# **SAVE OUR SANDLINGS**

Offshore Wind Farms  
**EAST ANGLIA ONE NORTH PINS Ref: EN010077**  
&  
**EAST ANGLIA TWO PINS Ref: EN010078**

Deadline 8 Response  
from  
**Save Our Sandlings**

Issue specific Hearing 12

Access Locations and Associated Onshore Infrastructure

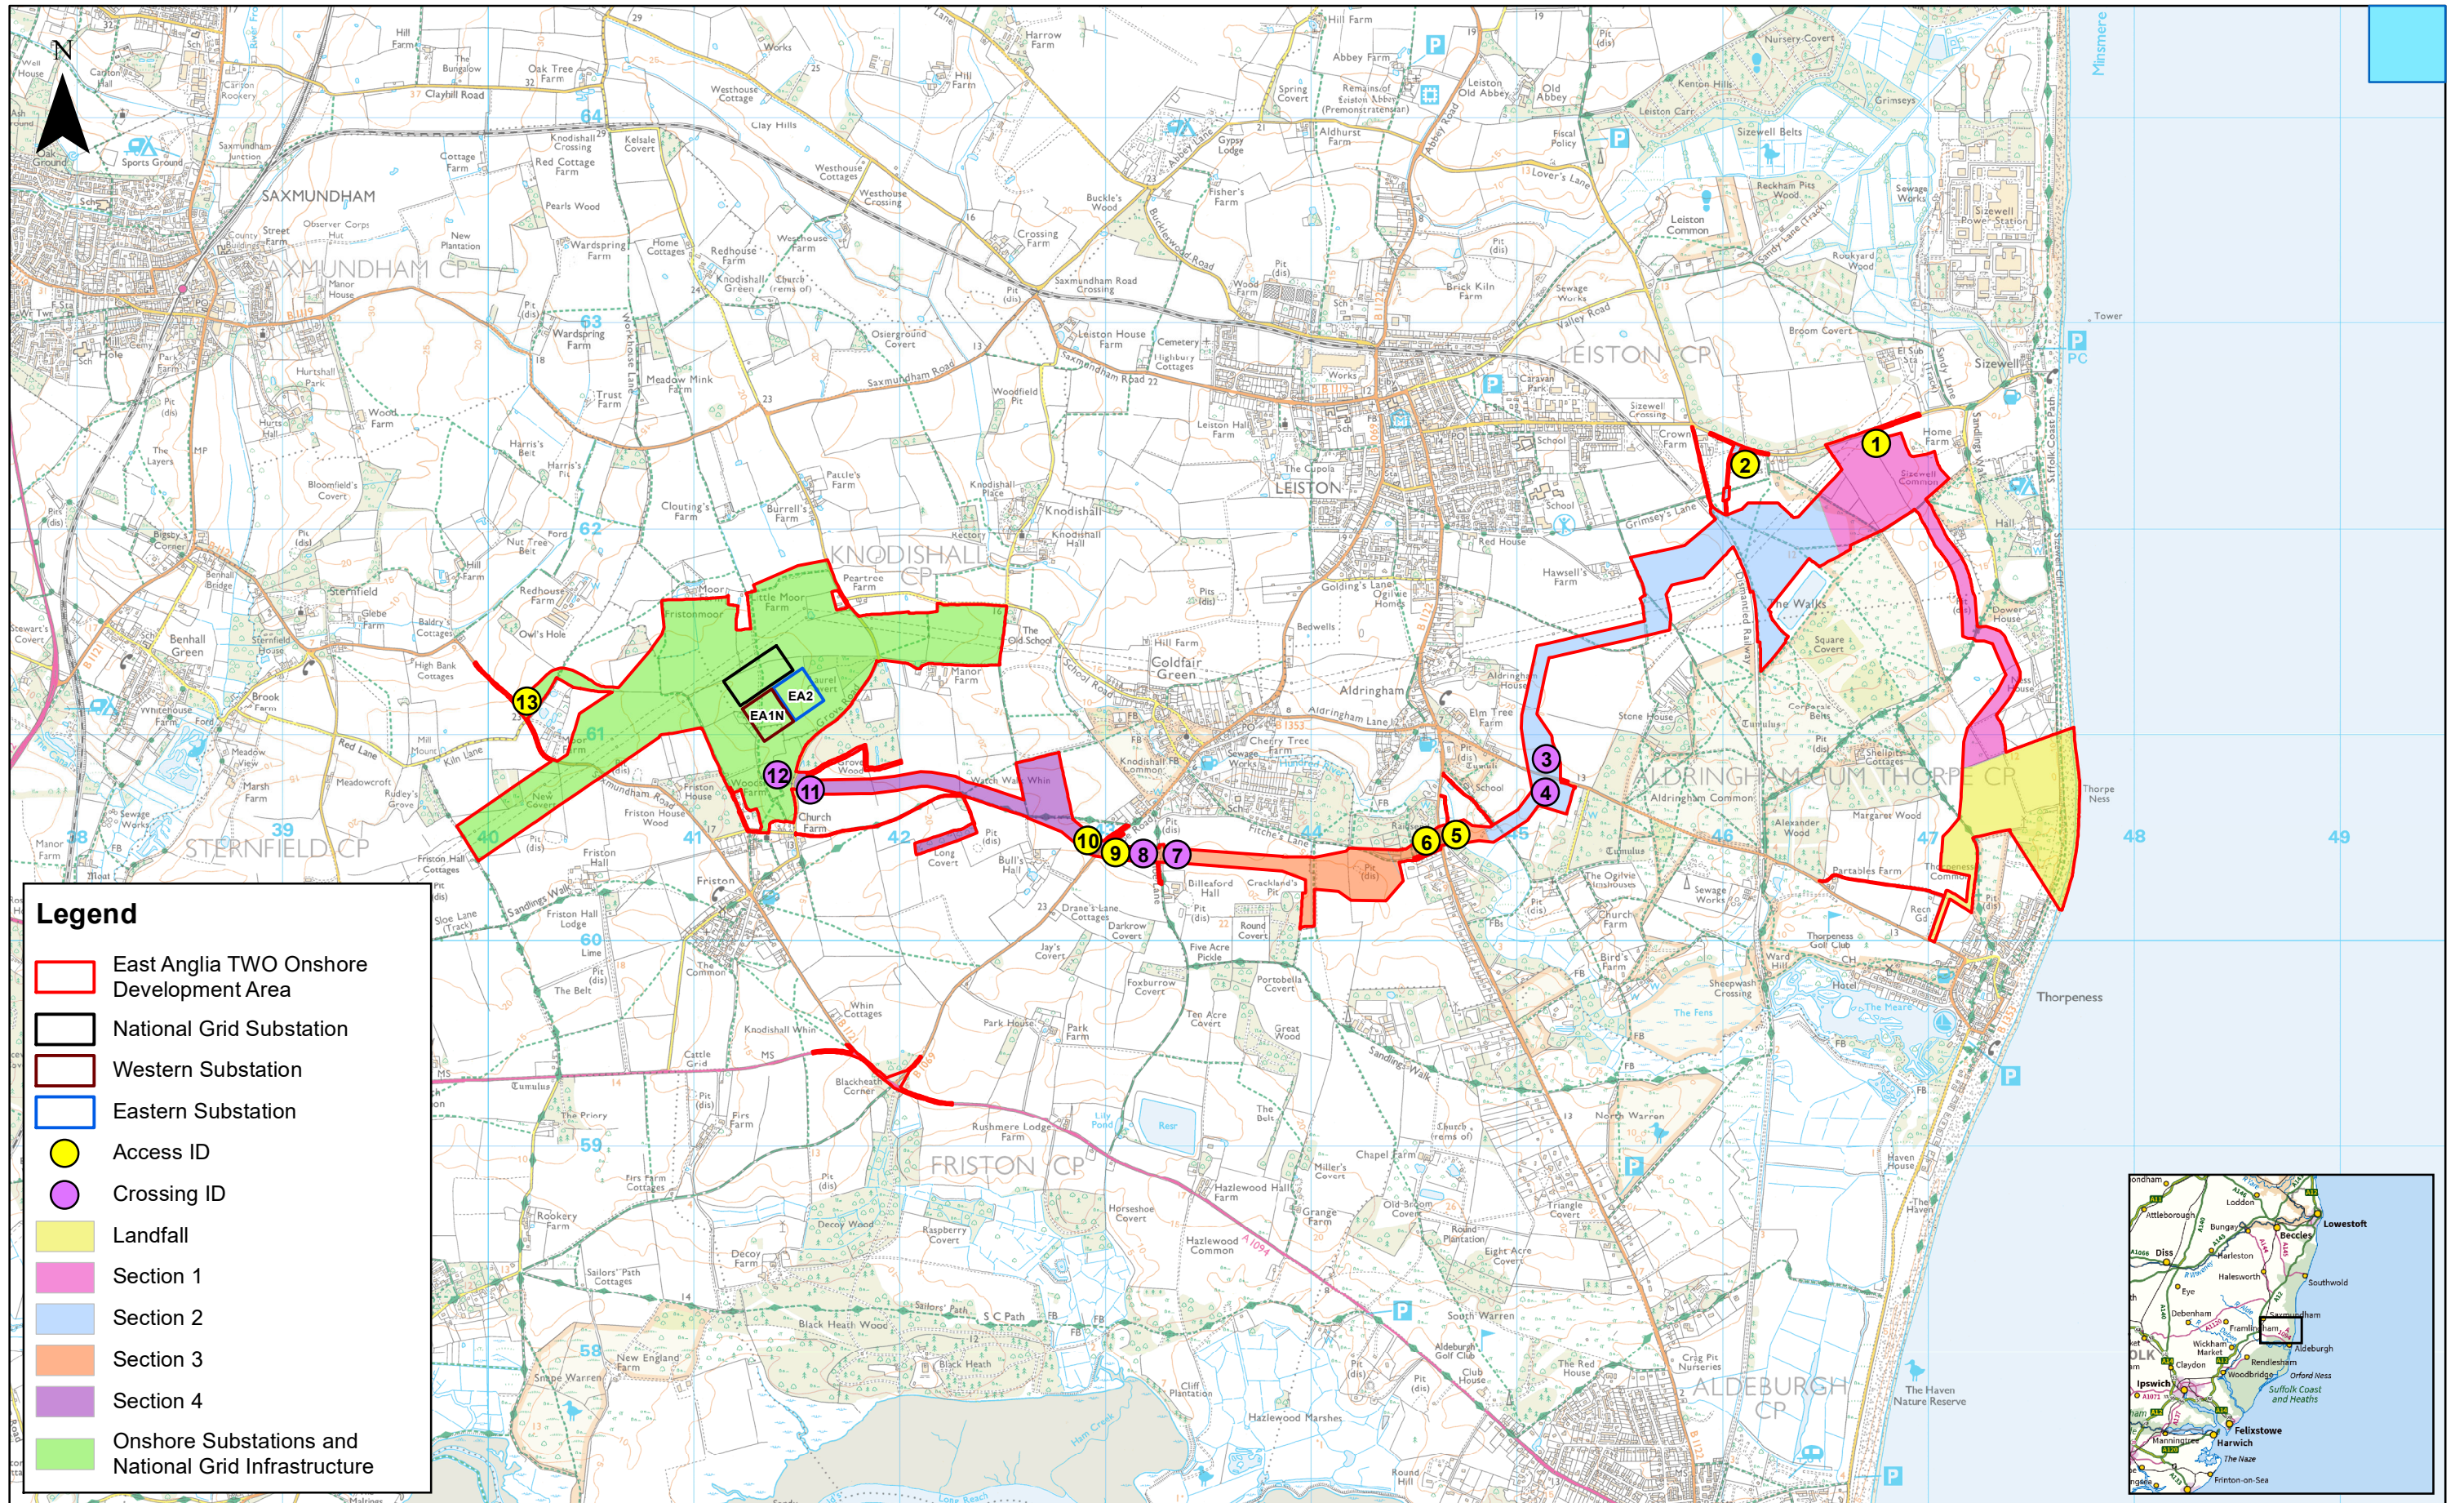
Access points 1 and 2 on Sizewell Gap Road (see map below) are respectively within 400 and 250 metres distance from CCR4 and generators for security will be extremely noticeable both in pitch and amplitude, especially at night introducing lower frequency sound and possible harmonic vibrations.
